Application for Removal or Variation of a Condition following Grant of Planning Permission or Listed Building Consent

Erection of a single storey side and rear extension and conversion of garage into habitable use with amendments to fenestration (revised description and plans)

62067/APP/2023/622

Cad File	Sheet Size	Scale
P001	A1	1:100
Drawn by	Drawing Date	Approved by
BR	FEB.2023	-
Project No.	Drawing No.	Revision
0221	P202	C

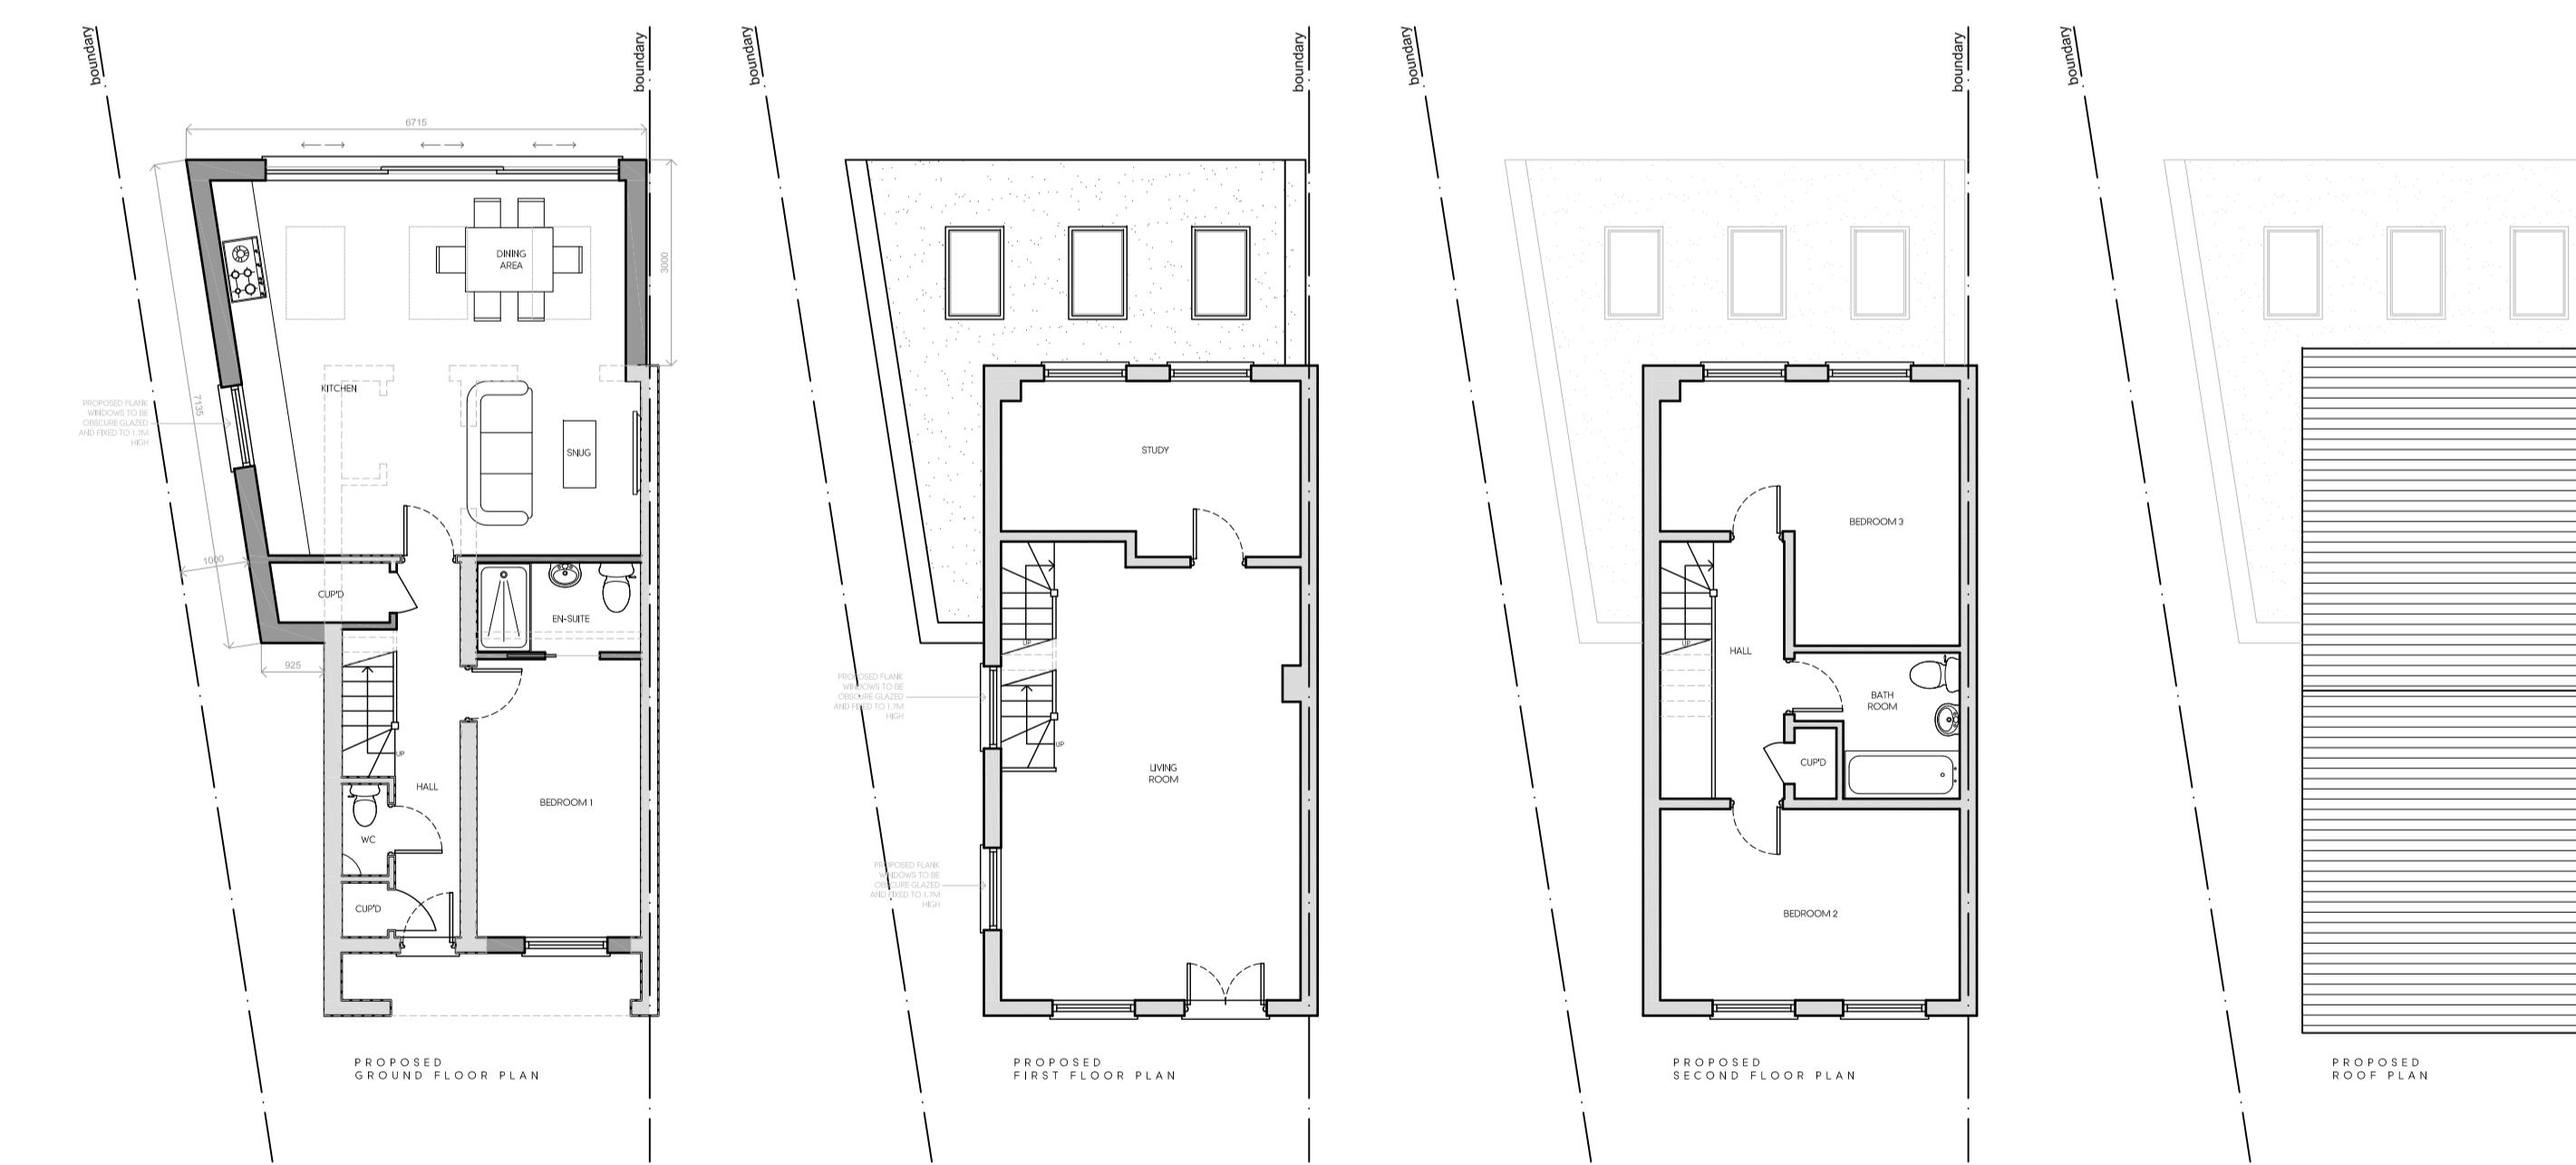
We require the condition 02 to be changed to include the latest amended drawing - P101, P102, P103, P201, P202C, P301C, P302A, P401C - which has been amended to show one additional obscure glazed window at ground floor level and two obscured glazed windows at first floor level on the left flank wall to allow more light into the living space.
